Application No: EP/7/21/HH

Site Address Little Dormers 23 Upper Drive East Preston BN16 1QN

Objections/Comments to New Windows on Planning Application EP/7/21/HH

Drawing No Status Revision
203075/ 010

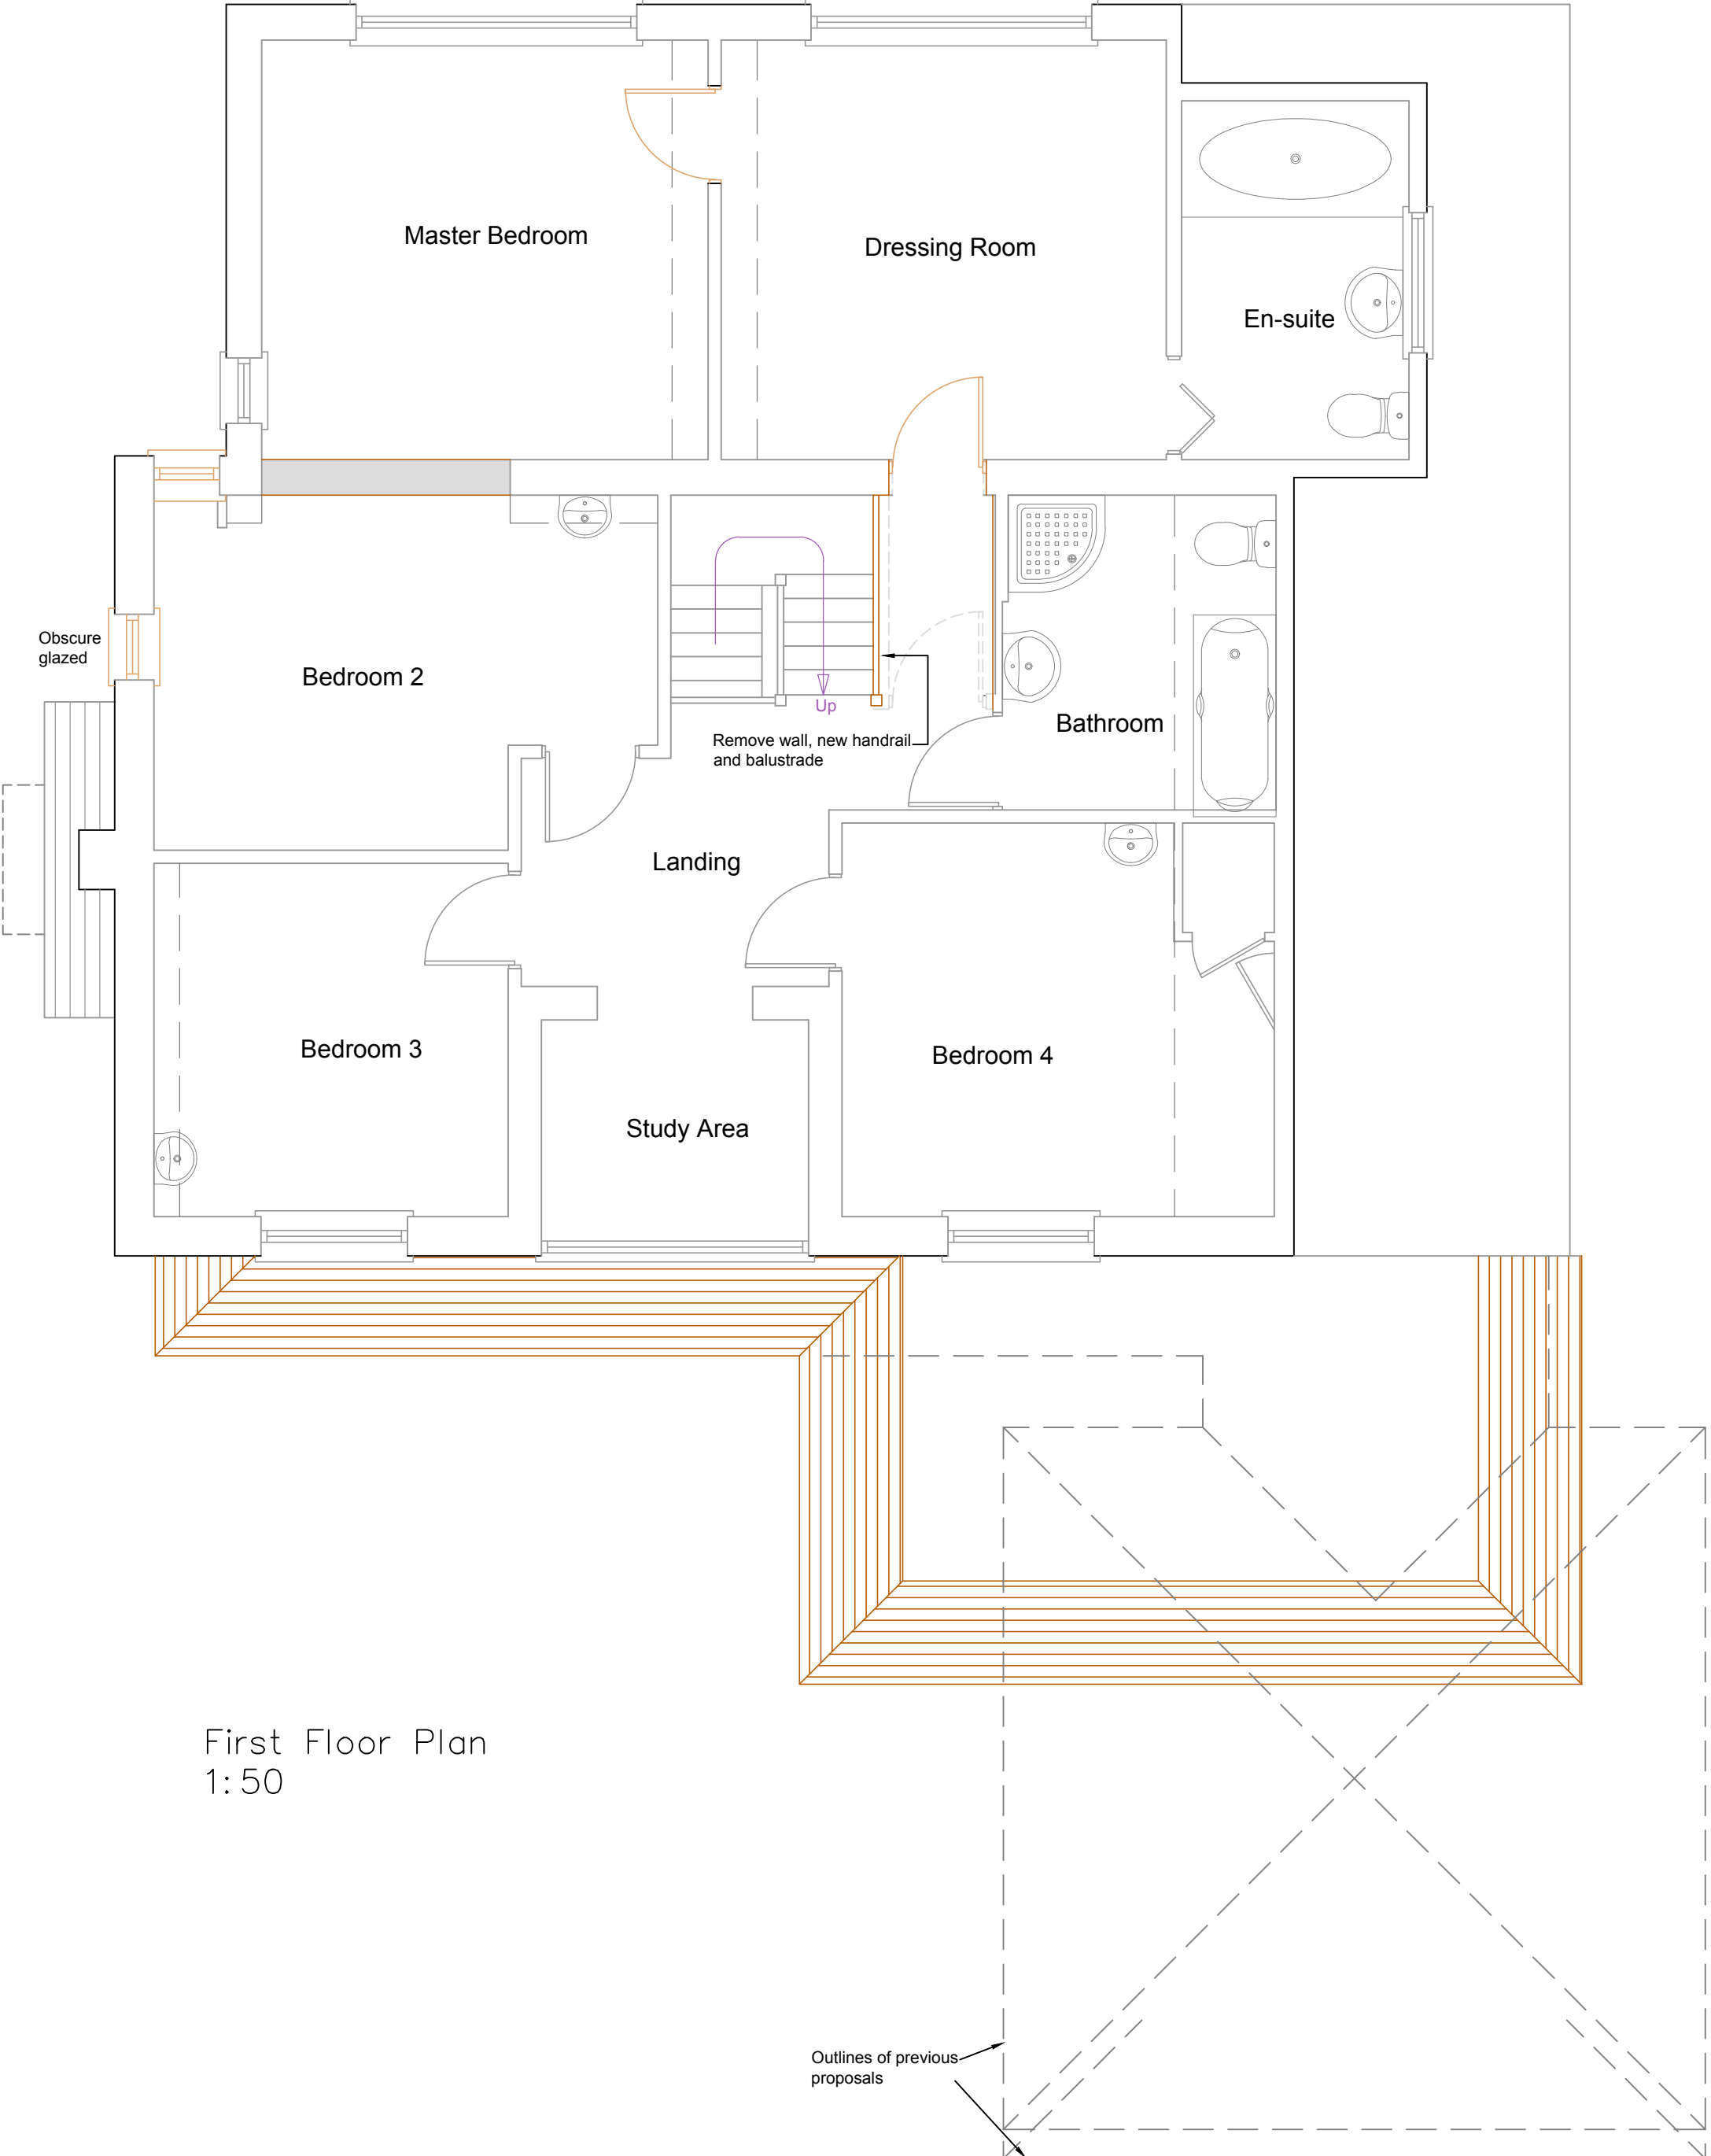
It appears that the only purpose of the new windows is to change the first-floor layout of the existing four bedrooms. However, In the second application, a further change was made to this layout. This increased the dressing room size and relocated it the north side of the house (Drawing 203075/10). This latest change of layout renders the existing side window redundant, but the application shows the window still exists. If removed, all existing problems of privacy would be solved for both parties (2.3, above).

We seriously question the need for two windows in the bedroom that has been moved.

Drawing No Status Revision
203075/ 011

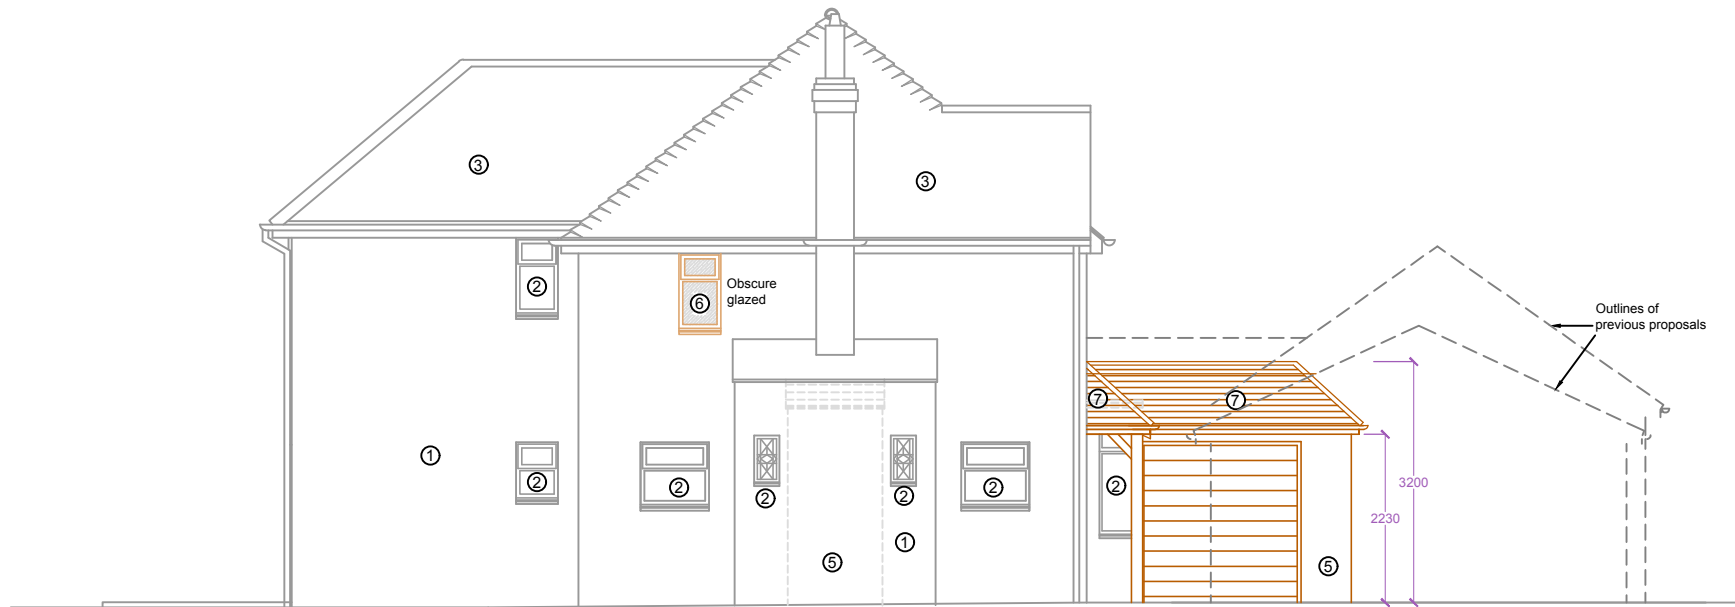
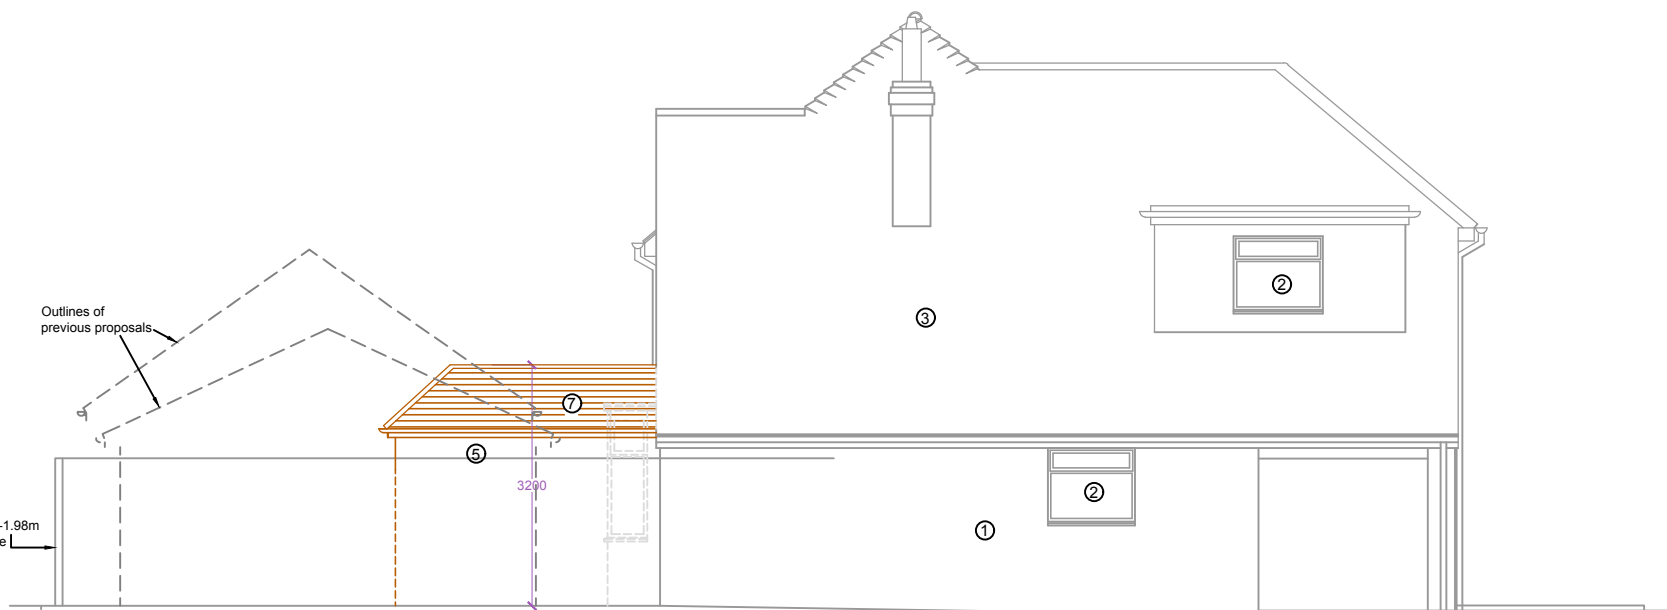
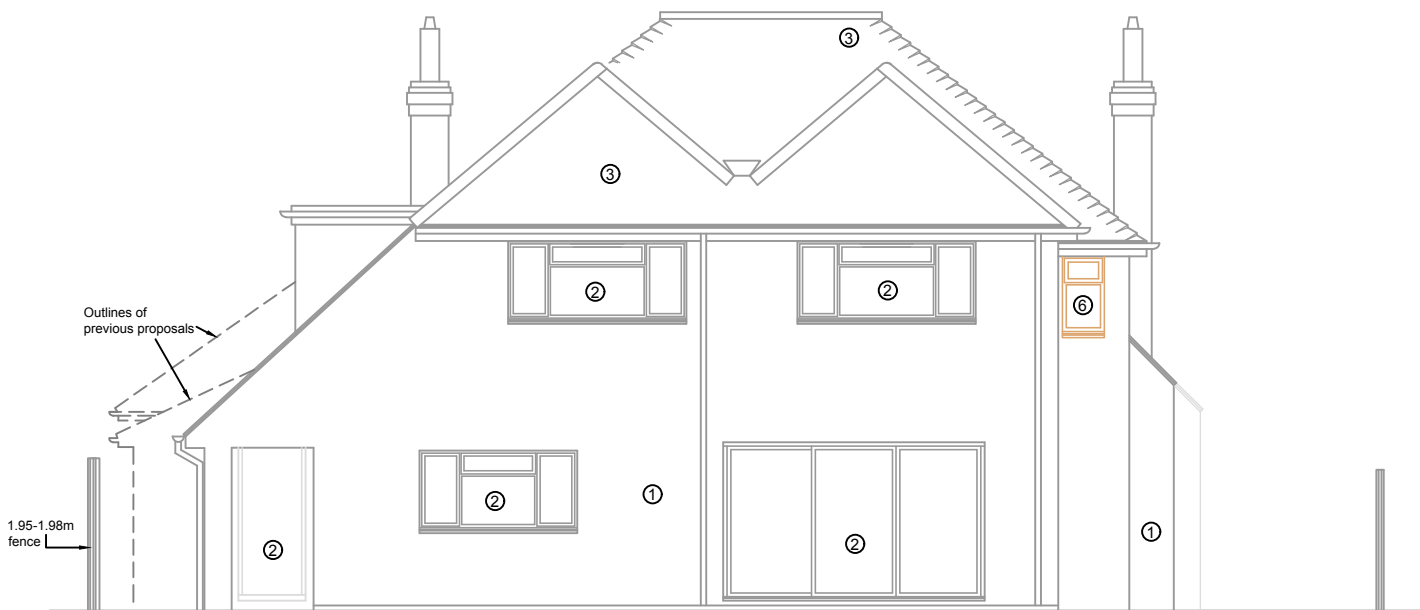
The most westerly of the two new proposed windows can be seen only by reference to the West Elevation (rear) drawing Plan (203075/011). This window has the much more intrusive, and angled view into 59 Manor Road than the existing window. This window would also be immediately above the well-used 'sunny' patio area, being the only place where the small, north-facing rear garden can consistently follow the sun without being in the shadow of its own building. This window, with a new, differently angled view, close to the existing one, would provide a dual-aspect view from Little Dormers into most parts of our garden and our main living area. This window placing is also not compliant with D DM4 a (see 4.1,3 &4 below)

1. Why is there a need for two windows in one bedroom?
2. Why would you create an unbalanced internal design-layout with this window placing?
3. Why is one window placed at right-angles and immediately next to the existing one, creating an undesirable situation where both bedrooms look into each other?

4. Why create an eye-sore by placing the above window at a different level to the immediately adjacent, existing window? The placing of any new window here is effectively ruled-out by being next to the existing, higher window, which will always be the case because of the higher roof-height in the extension by, say, around 15 to 20 inches. This imbalance of placement would create a visual eye-sore on the external face of the building. It would be a poor architectural design feature, highly visible from our property. ***(Note: This imbalance can only be seen by a site visit; looking at both elevation plans together, it is difficult to detect)***

Aside from the highly significant privacy issues, the placement of one of the proposed new windows does not demonstrate a high-standard of architectural principles; it is out-of-line with the immediately adjacent, existing one, and both windows look into each other (*D DM1 Appearance/Attractiveness*). This window placement is not sympathetic to the existing elevation, and will significantly harm the visual integration of the original building with the extension (Policy D DM 4, Extensions, items a) & c)

However, continuing in our efforts to being constructive, if the Planning Officer should want to consider an amendment to the application, we would suggest the following conditional option: Remove the plan for a window that provides the new, angled view into 59 Manor Road, and replace the other proposed window with a high-level one 1.7 metres above the floor level. It could be extended horizontally for adequate light and opening(s). This type of window would not be overlooking and be less overbearing in its effect; it could not easily be converted to a standard window. It should be conditional that the existing window must be removed. (There is now no valid need to retain this window (2.4, above). This would retain the status quo of one window, and make it more compliant. It would also provide architectural harmony.

- 3) Consider the alternative of one high-level window, at a minimum of 1.7 metres above the floor-level of the first-floor. This has no potential for removing obscured glass. The room can be used without giving intrusive views to any of the parties. This would be conditional on the now redundant, existing window being removed. This is necessary for privacy and to provide architectural harmony. It also means there would be no increase in the number of windows.
